**From:** [Dan Grove](#)  
**To:** [Molly McGuire](#)  
**Subject:** Existing Grade for permit 2207-019 SUB3  
**Date:** Friday, June 9, 2023 9:00:14 AM  
**Attachments:** [2207-019 Existing Grade - for SUB3.pdf](#)

Molly McGuire  
Mercer Island Community Planning and Development Department  
RE: Permit 2207-019 SUB3 / 6950 SE Maker Street  
Jun 9, 2023

**BASEMENT FLOOR AREA CALCULATION**

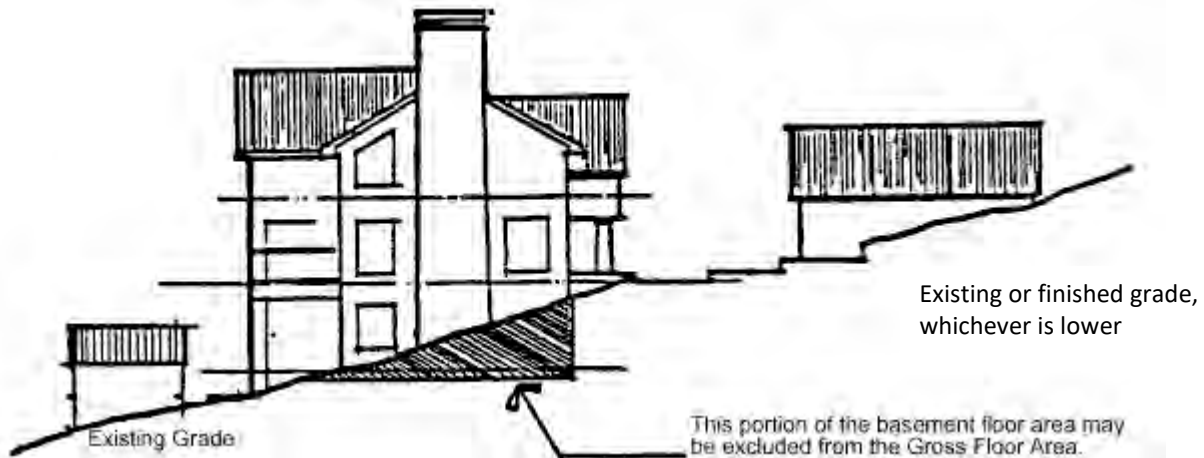
The correctly-determined Existing Grade for the proposed structure can now be used to correctly calculate Basement Coverage and Average Building Elevation. For SUB3, the results of using the correct Existing Grade are as follows:

For Basement Coverage (using the plan's Basement FF of 226.7')

- West Basement Wall Coverage:  $0\% * 46'$
- North Basement Wall Coverage =  $37.5\% * 35'$
- East Basement Wall Coverage =  $60\% * 46'$
- South Basement Wall Coverage =  $0\% * 35'$

Therefore, Basement Coverage is 25.1%.

- Yard depth of the East Side Yard is 7.5' in this submission.
- 19.02.020(D)(1)-(2) - Because Existing Grade is computed incorrectly, the Basement Exclusion is computed incorrectly. As a result, the computed GFA is incorrect.

- The correct calculation for ADU square footage is  $586 * (1.0 - .251) = 438$  square feet, which is 100% of the allowed ADU square footage.
  - The correct calculation for non-ADU Basement Square Footage is  $1024 * (1.0 - .251) = 767$  square feet. As a result, the non-ADU square footage is  $767 + 1669 + 1529 + 66 = 4031$  square feet, which is 531 square feet larger than the 3500 square feet permitted.
